**From:** Mark Warwick <Mark.Warwick@arun.gov.uk>  
**Sent:** 07 July 2021 11:38  
**To:** David West [REDACTED]  
**Cc:** Maria Tomalova <Maria.Tomalova@arun.gov.uk>; Planning.Responses <Planning.Responses@arun.gov.uk>  
**Subject:** Canal Mews Barnham - BN/66/19/PL Condition 12

I am satisfied that the pre-commencement requirement of Condition 12 has been met, with fencing correctly installed and located as per the approved Tree Retention and Protection Plan.

Drawing No. 02 - Tree Retention and Protection Plan
Land to the East of Barn Rise, Barnham

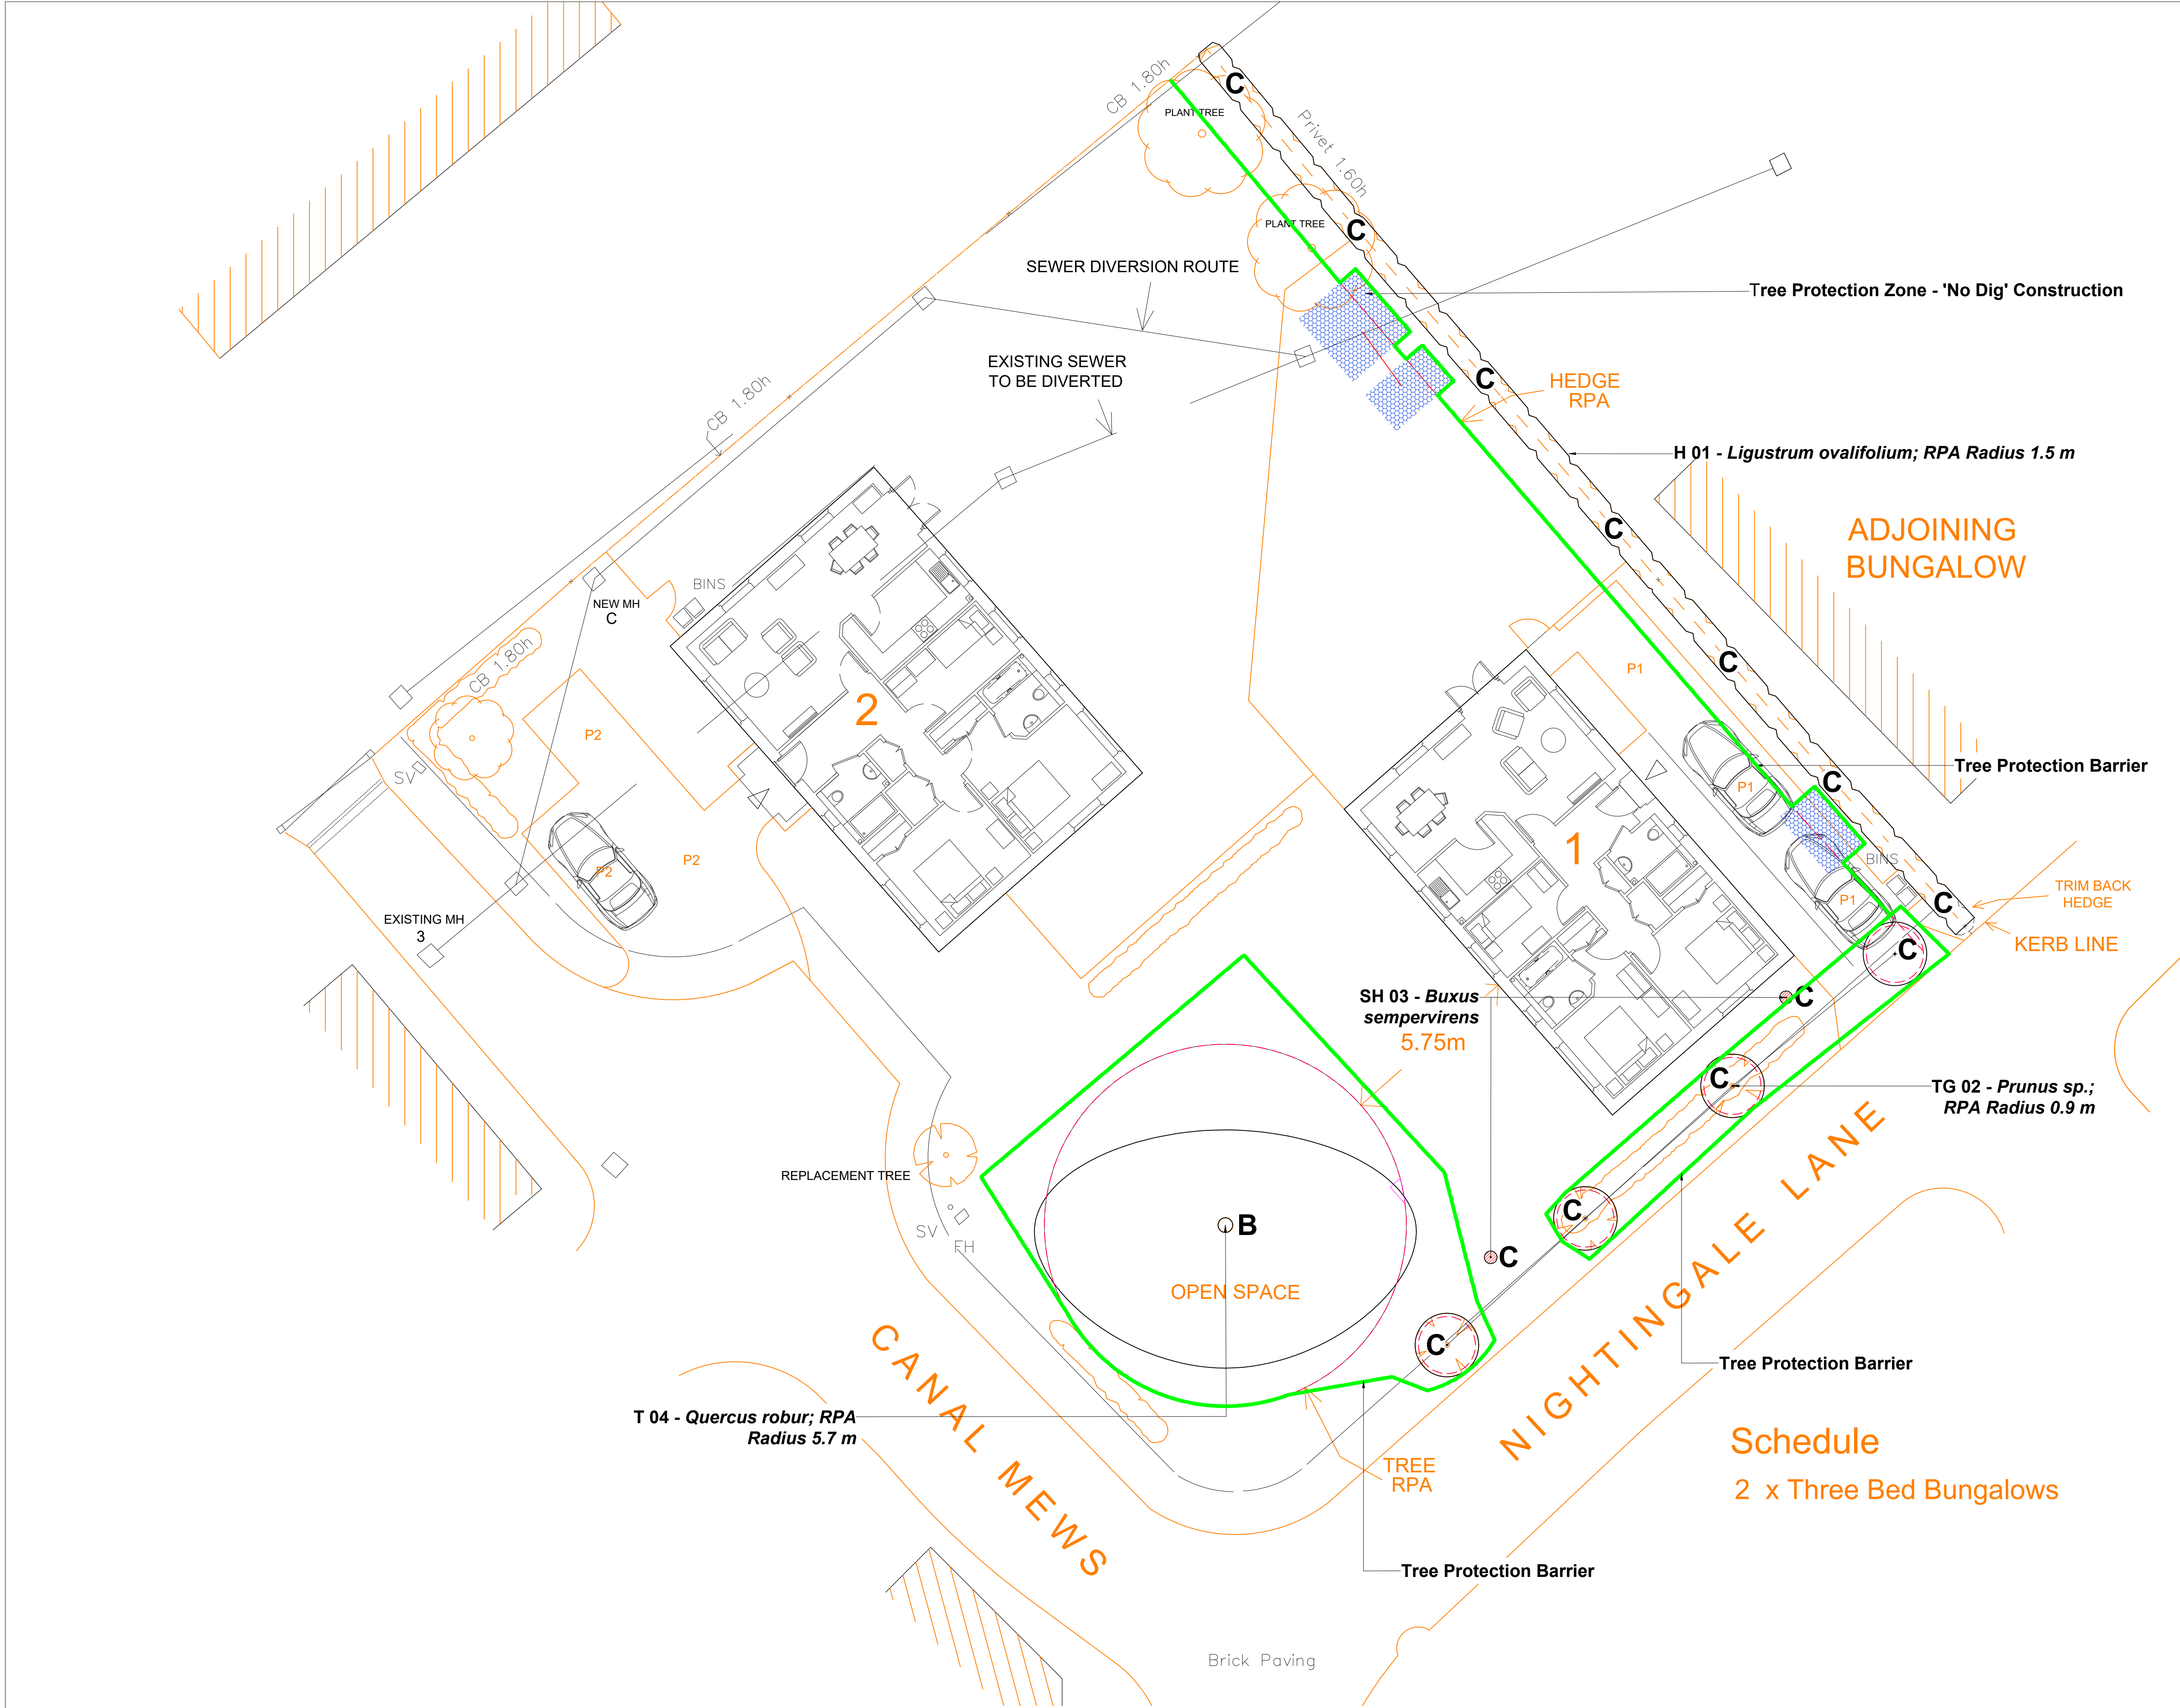
Please note that no building materials should be stored within a fenced-off area (Construction Exclusion Zone). I would be grateful if you could arrange prompt removal of the heavy bag shown in IMG\_2054.jpg. Such materials may be harmful to the tree's root system by way of ground compaction and/or soil contamination. I refer to the approved Arboricultural Impact Assessment & Method Statement, LLD 1345-ARB-REF-001 (para. 5.1.)

Further to our meeting on site last week to inspect the tree protection fencing I would confirm that it has now been moved so as to provide at least 5.7 metres between the fencing and the base of the tree. I have attached some photographs and trust that you will now be able to confirm discharge of the planning condition.
